TRI-LAKES MONUMENT FIRE PROTECTION DISTRICT

March 20, 2019

Applicant: Monument Academy School
CRP Architects, PC
David Jones (chipita1@comcast.net)

NORTH WATER LINE PLAN

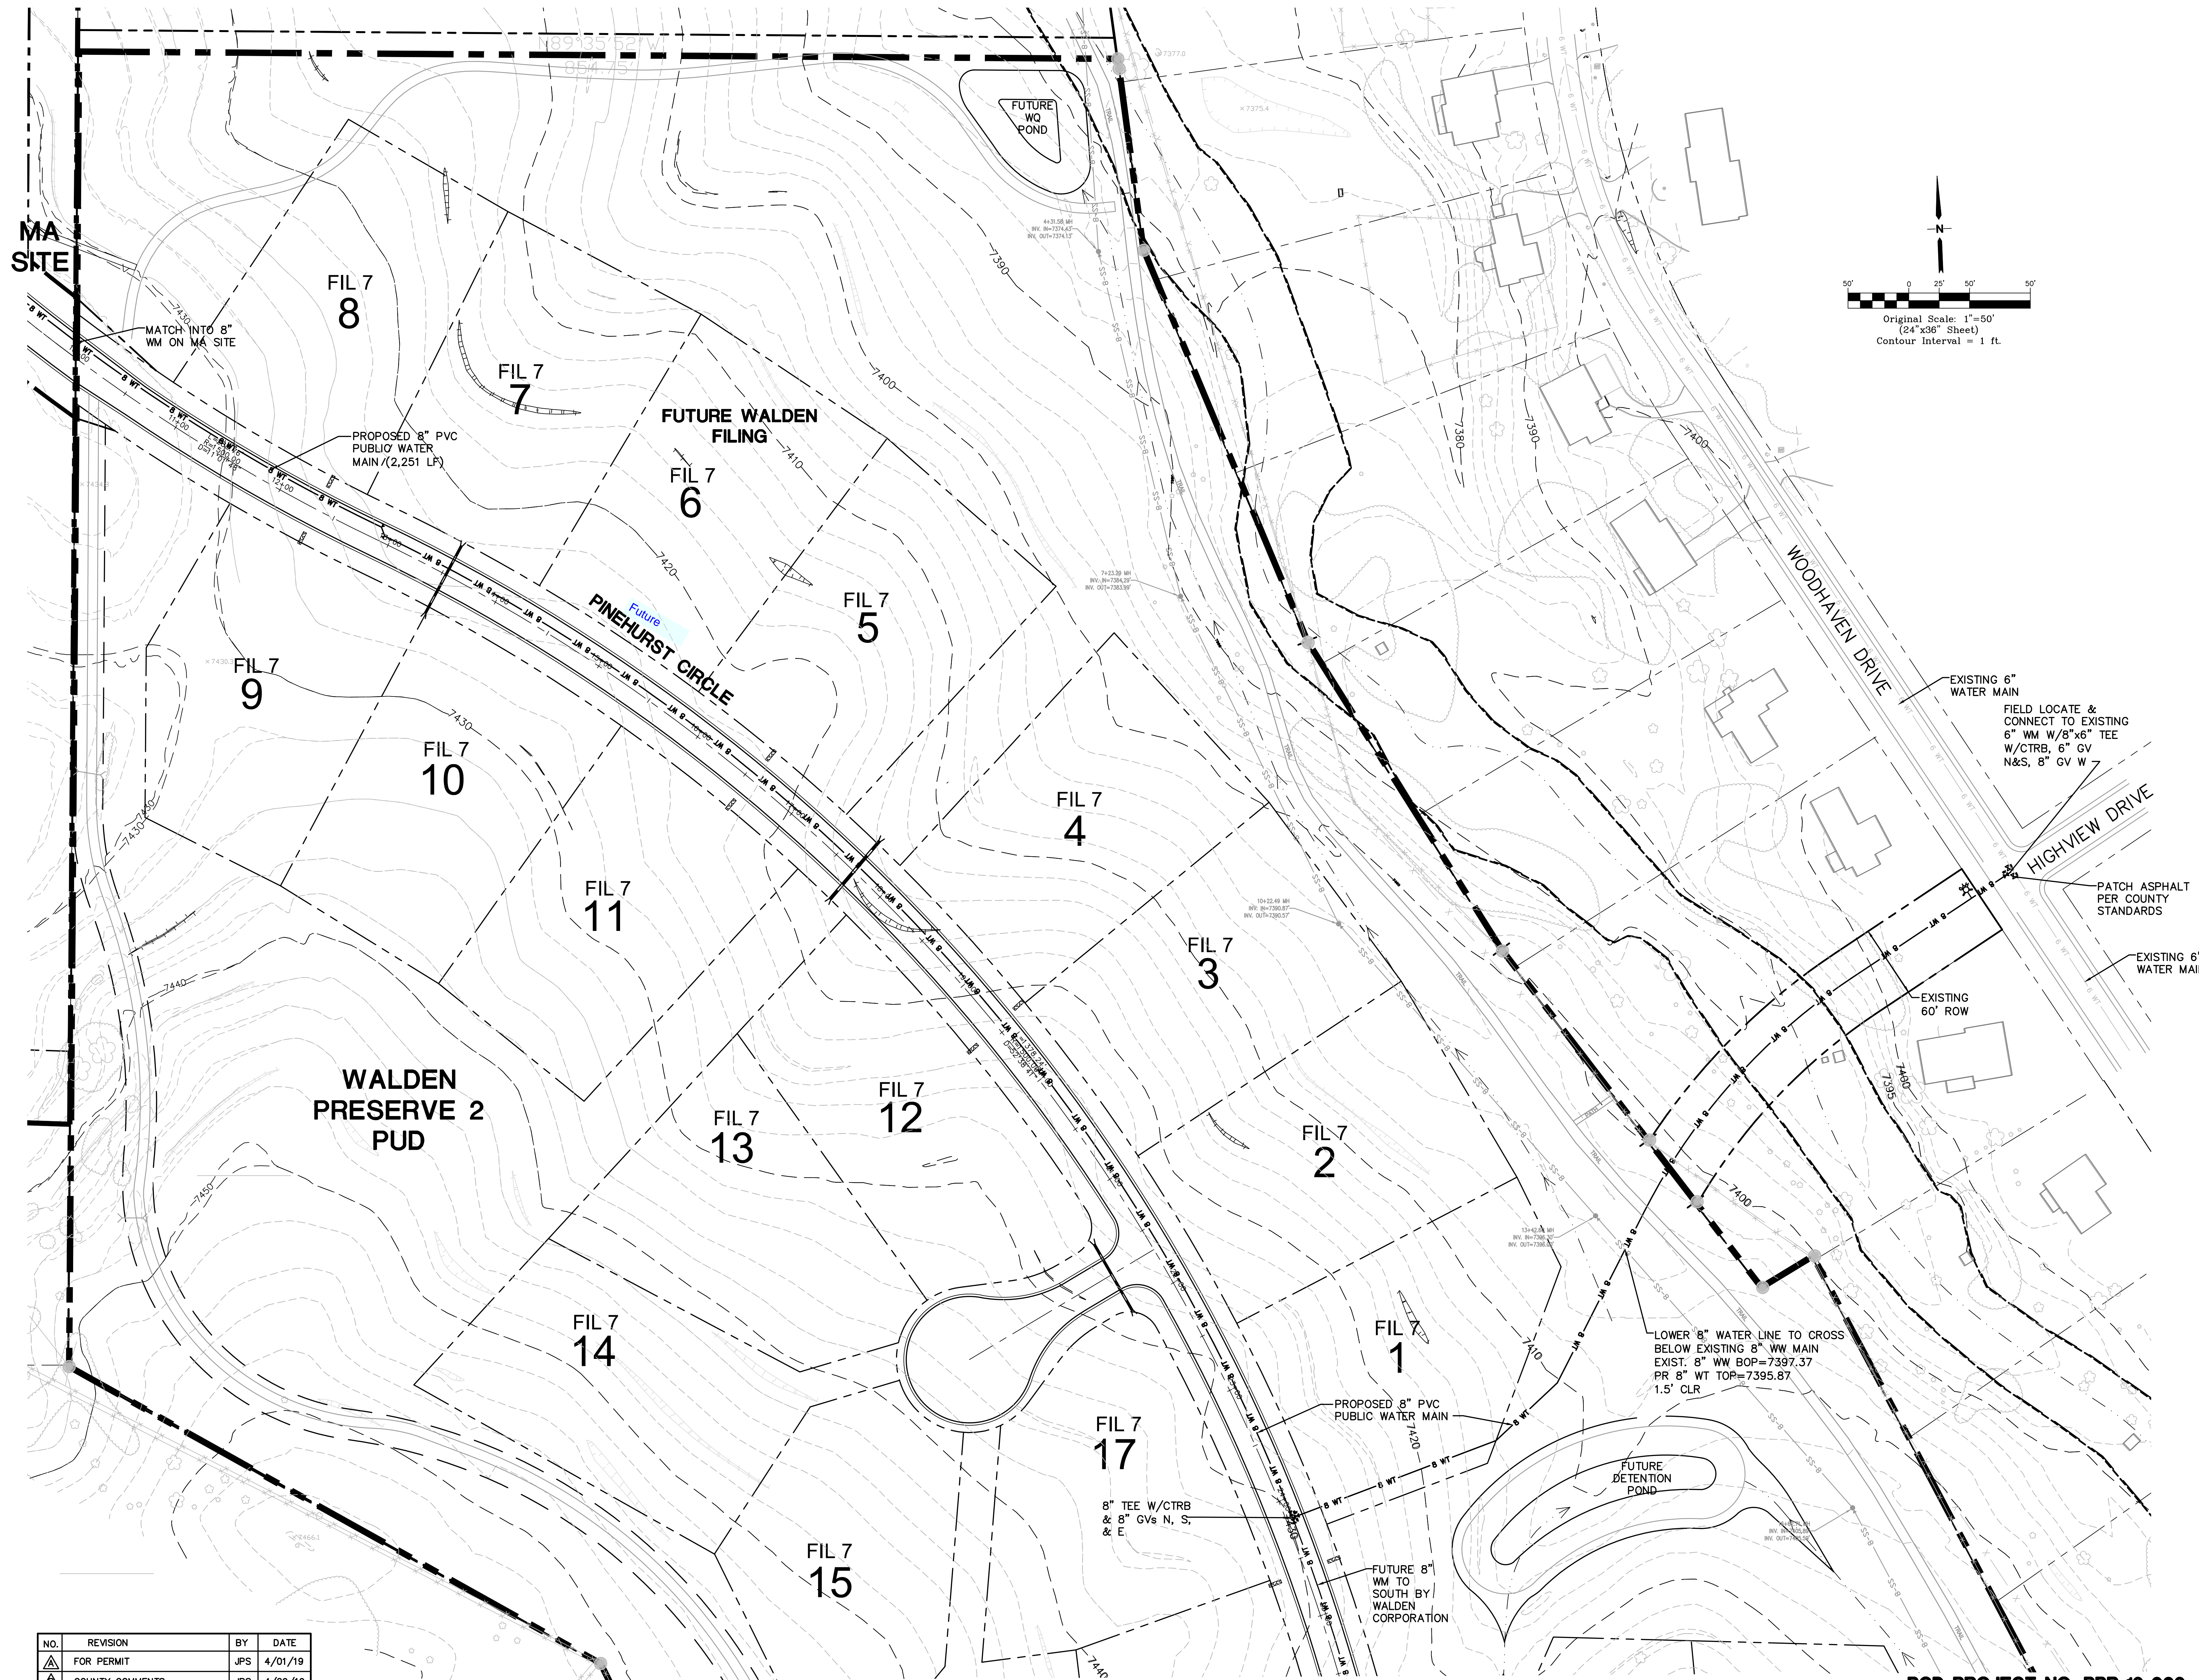
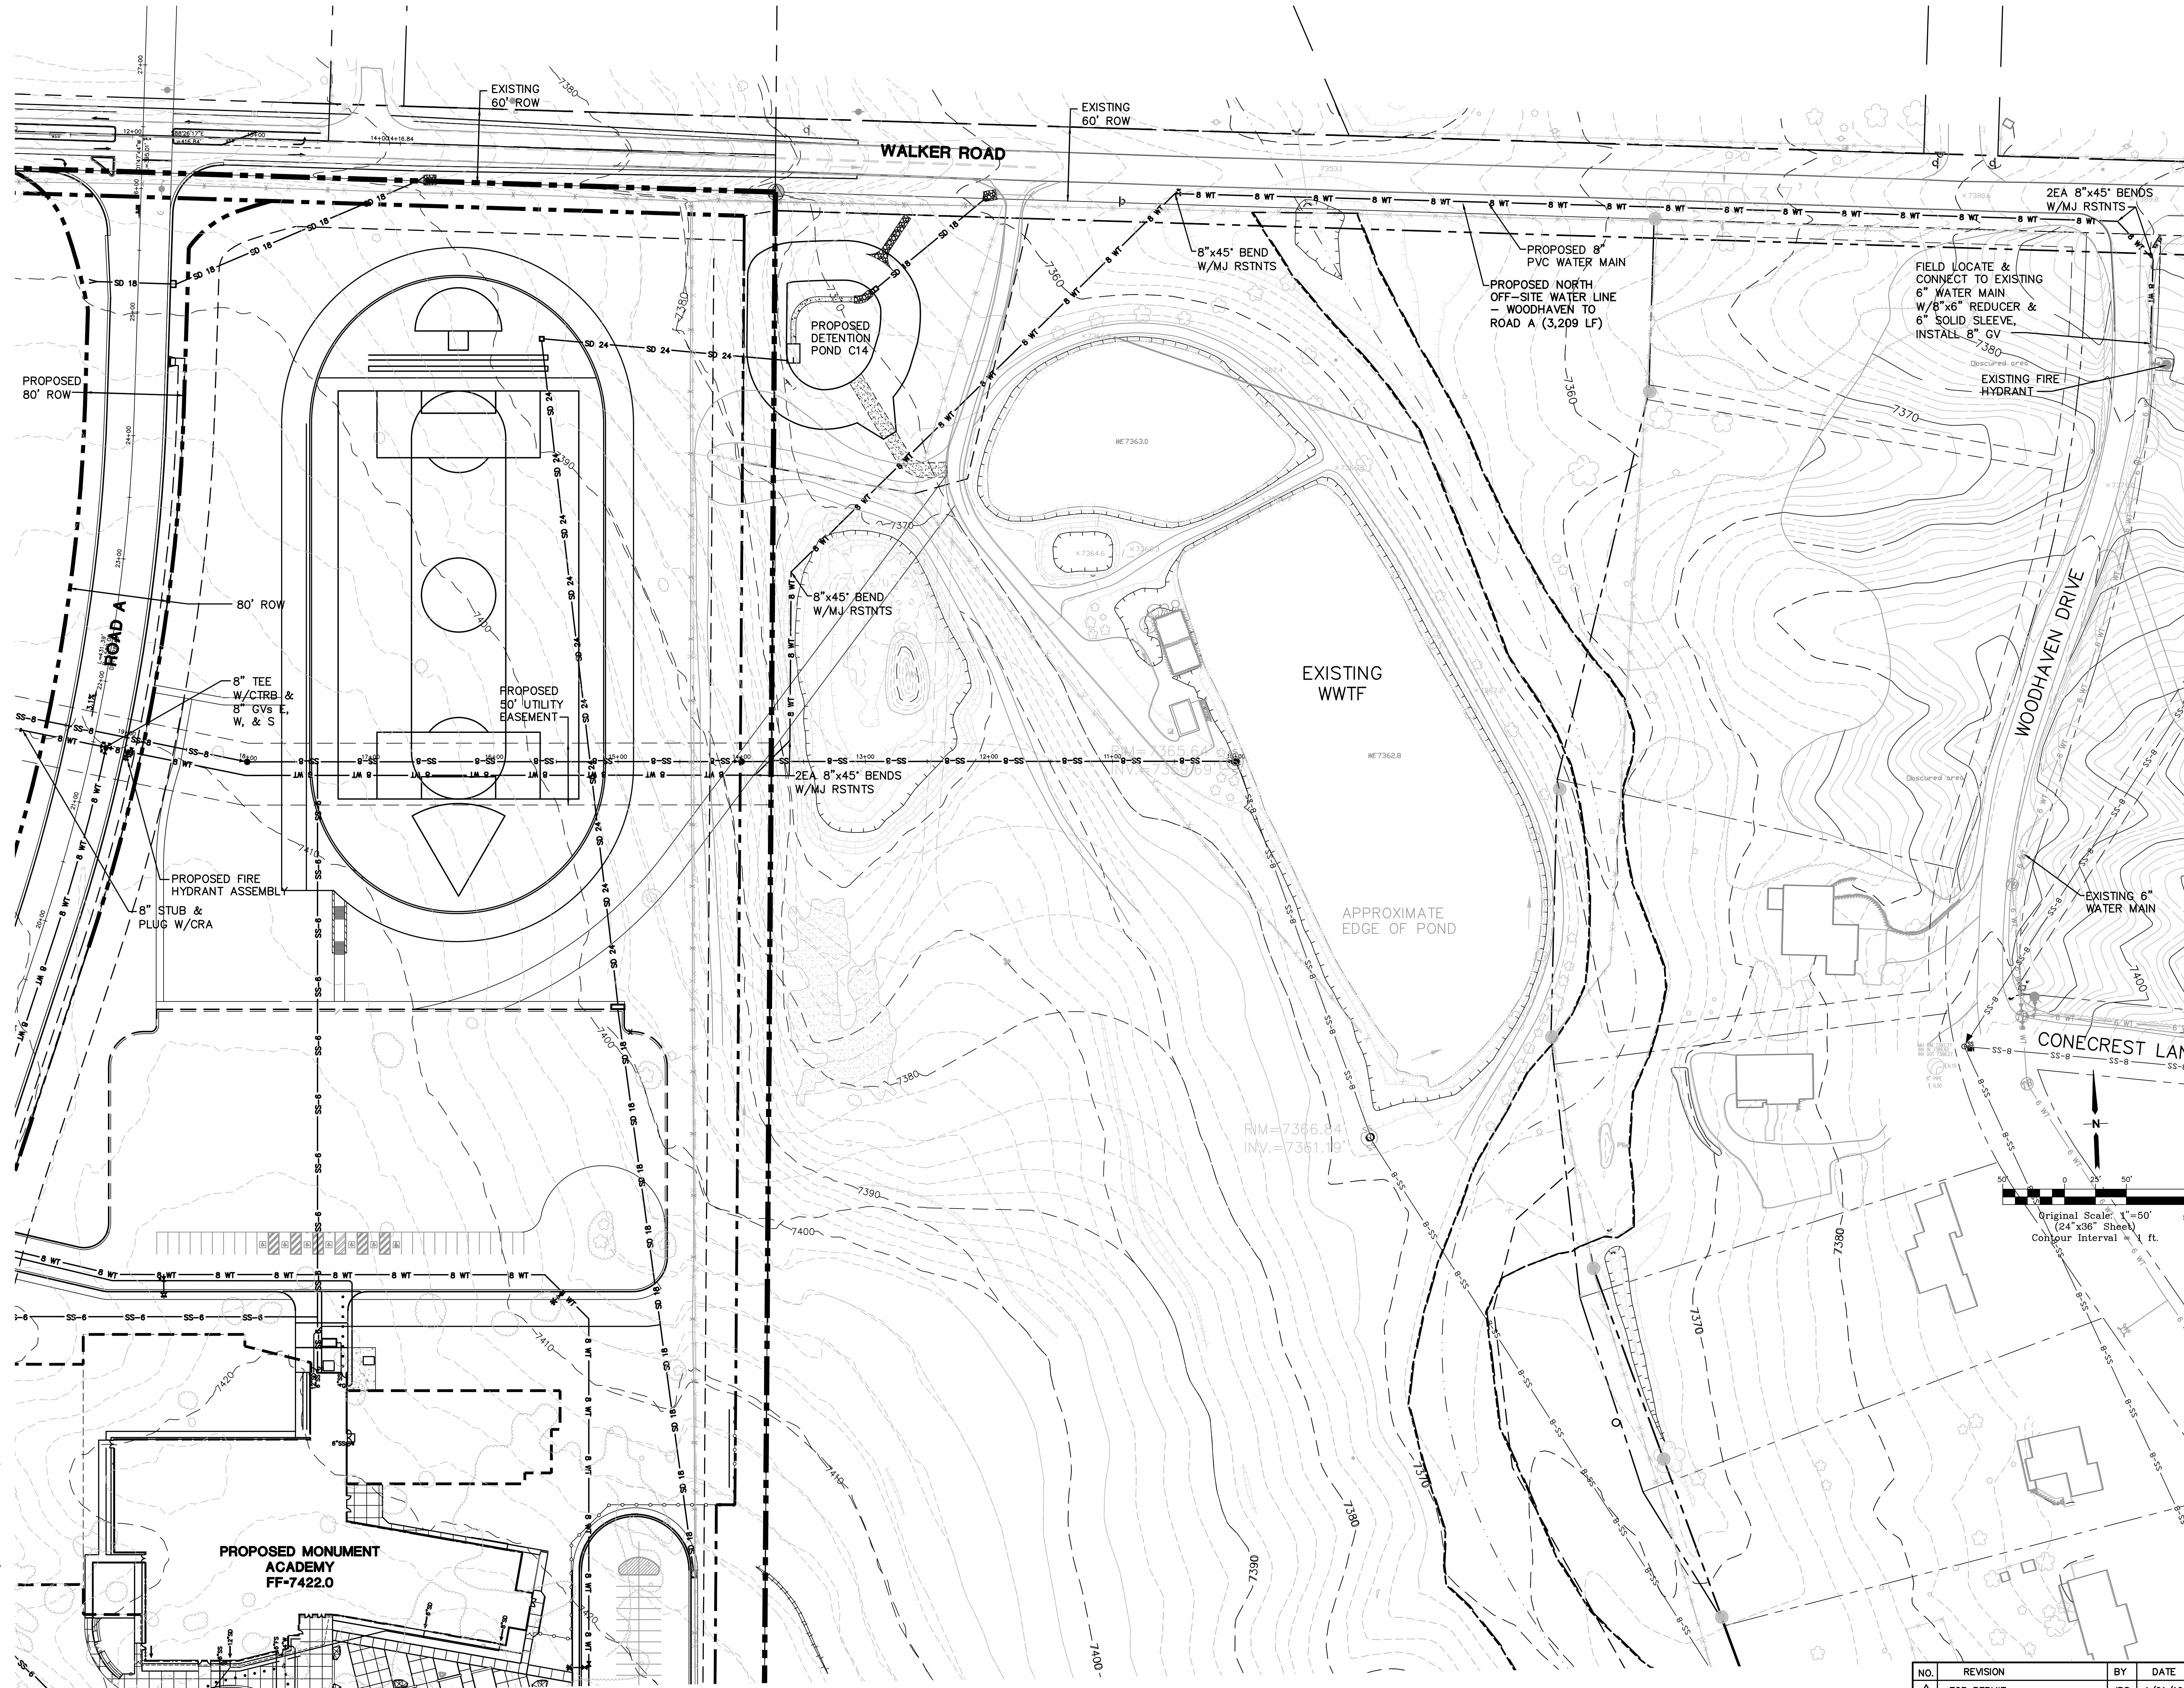
2. Fire hydrant(s) spacing/location per Appendix B. Additional hydrant(s) required.
3. Hazardous Materials: IFC-09/Appendix H has been adopted and shall be completed and submitted with the construction permit drawings as necessary.

8. Coordination with this site and possible development of nearby site(s) should be considered for fire hydrant placement and spacing.
